**WEST SUSSEX COUNTY COUNCIL
STRATEGIC PLANNING CONSULTATION**

**SUBJECT: LU/51/14 - Outline application for approval of access arrangements to serve
68 No residential units.**

**Land South of Littlehampton Academy, Elm Grove Road, Littlehampton, West
Sussex, BN17 6FE**

Scale	1:500	Drawn By	GSE	Checked By	PJC	Approved By	PMR
Drawing No.	13/1693/007	Date	February 2014	Rev.	A

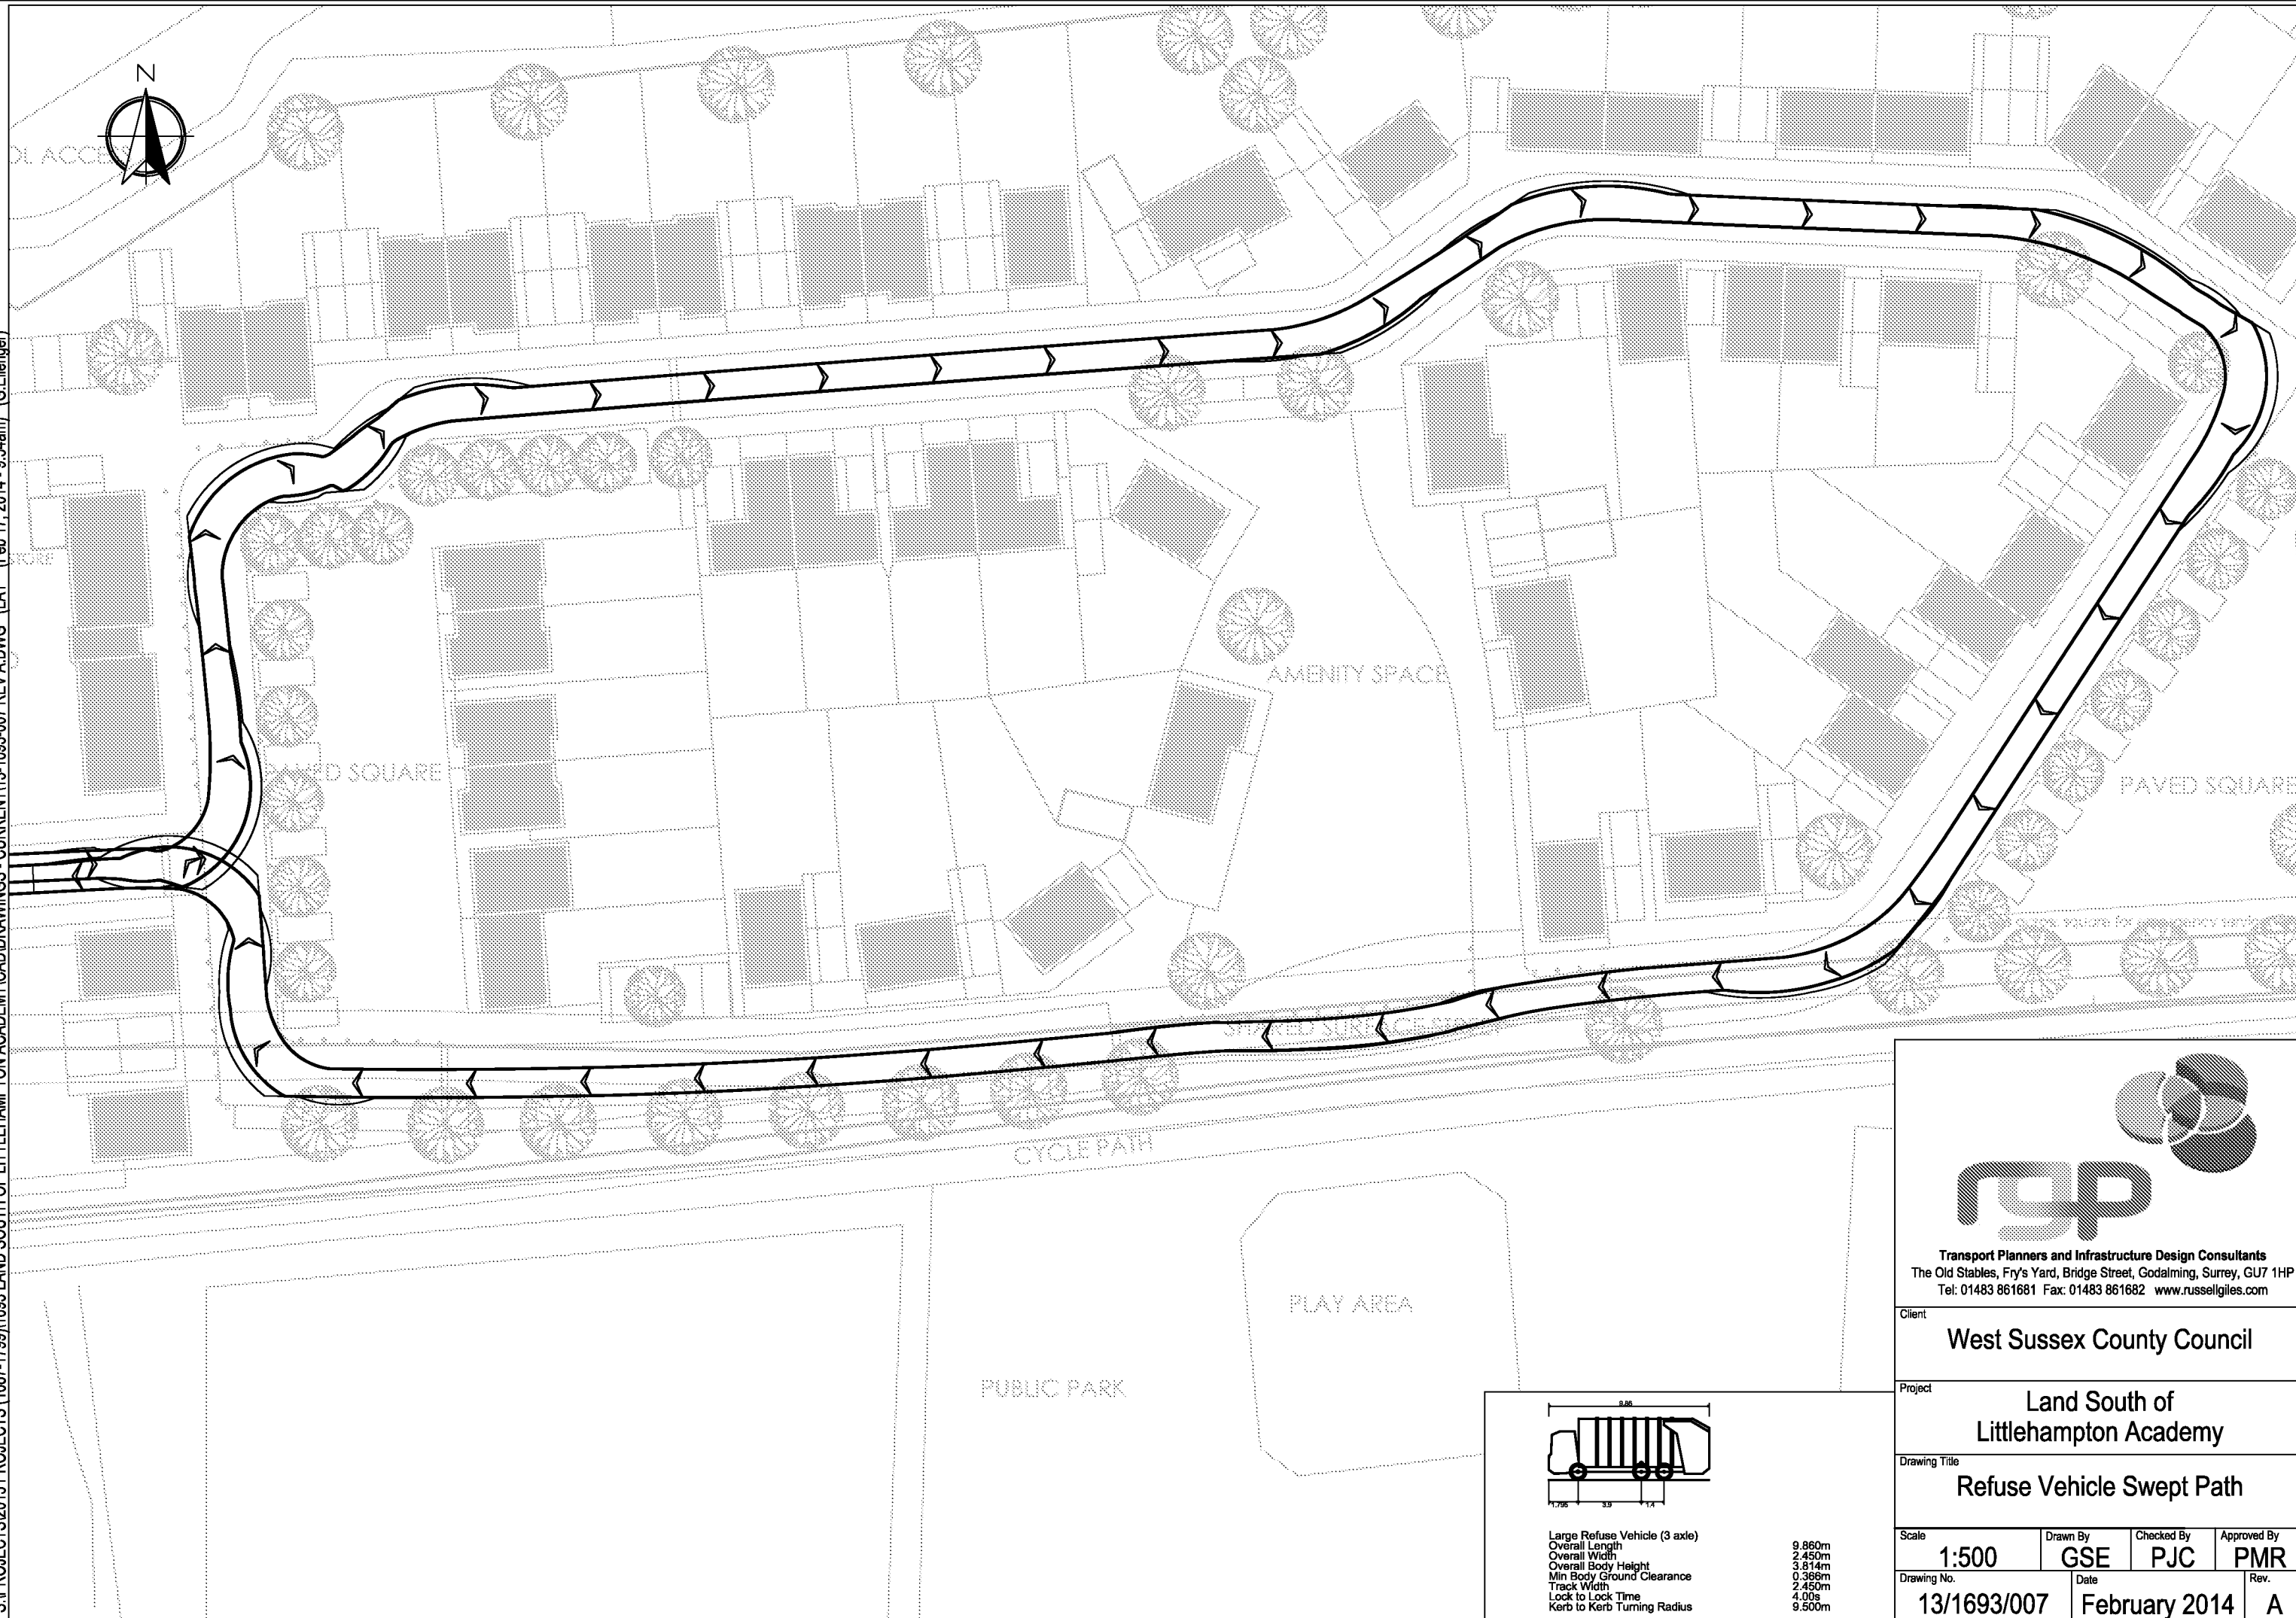
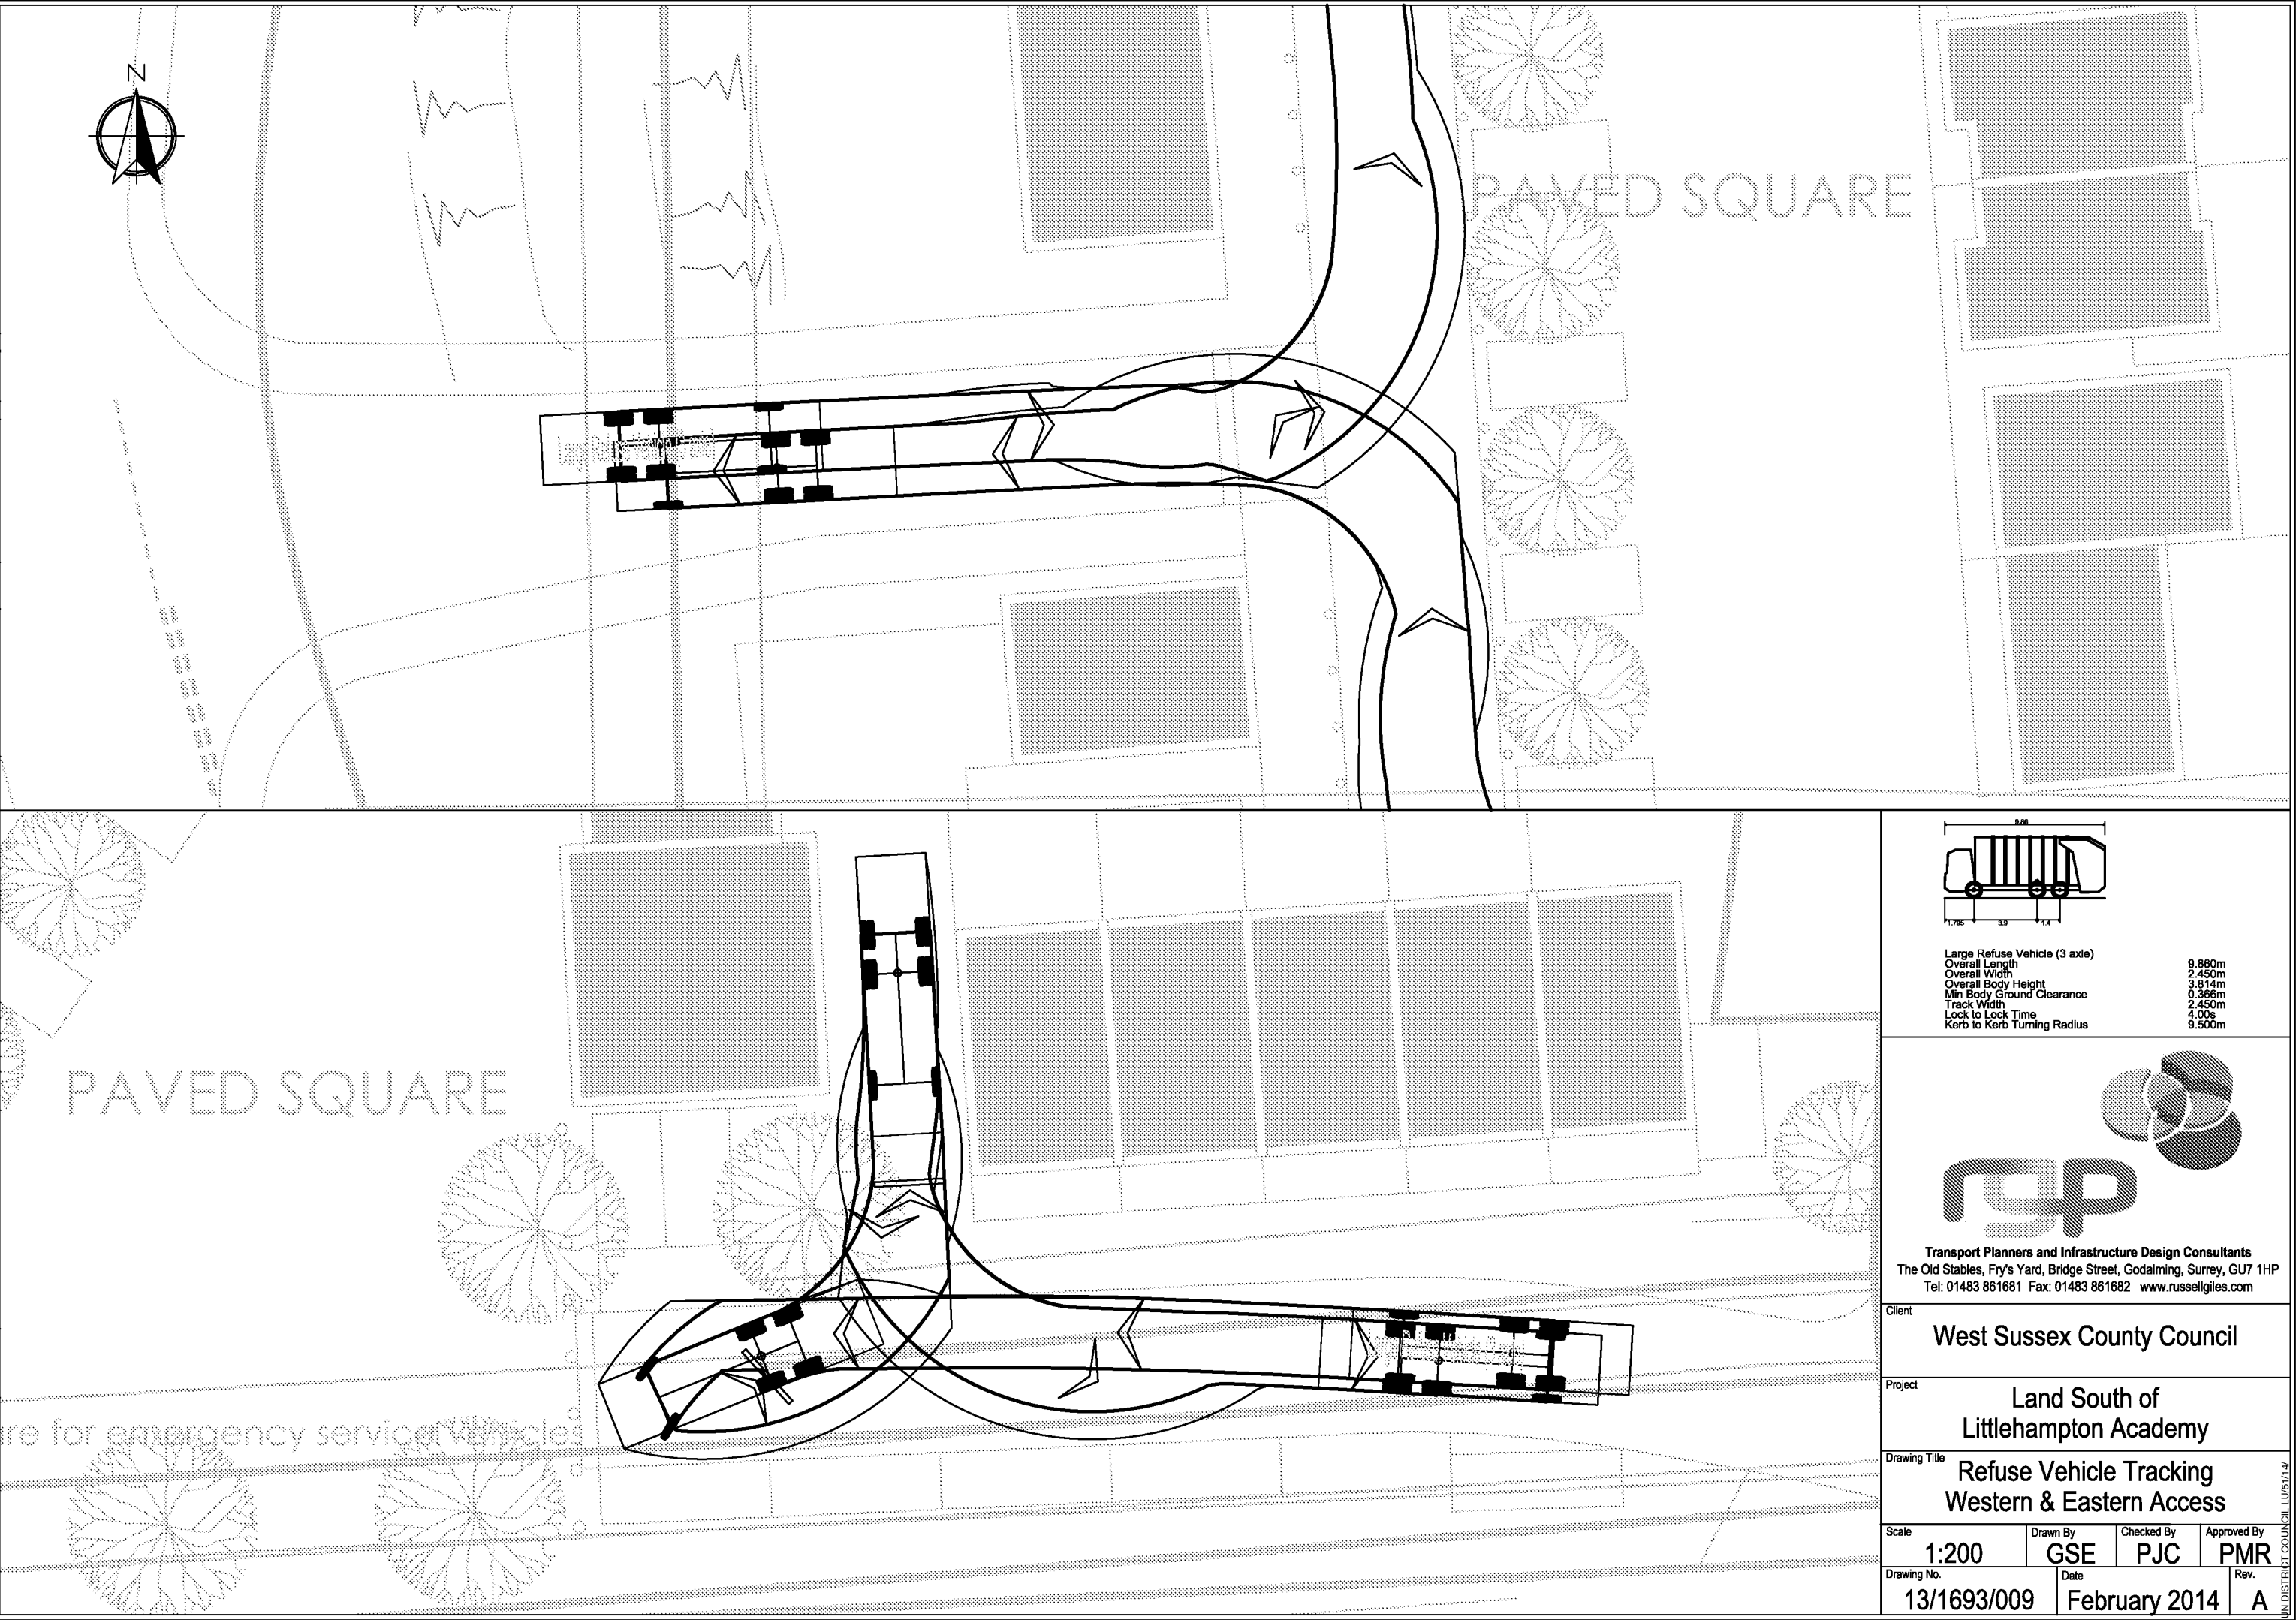
- Elements of the carriageways are quite angular and the alignment would be potentially difficult to negotiate if on-street parking occurs. The swept paths provided for a refuse vehicle clearly show that the alignment in places does not work as kerbs and footways are being over-run and the manoeuvring being quite difficult.

- On-street visitor parking does need to be better distributed throughout the development. The swept path for a refuse vehicle clearly indicates that any on-street parking would result in difficulties for manoeuvring.
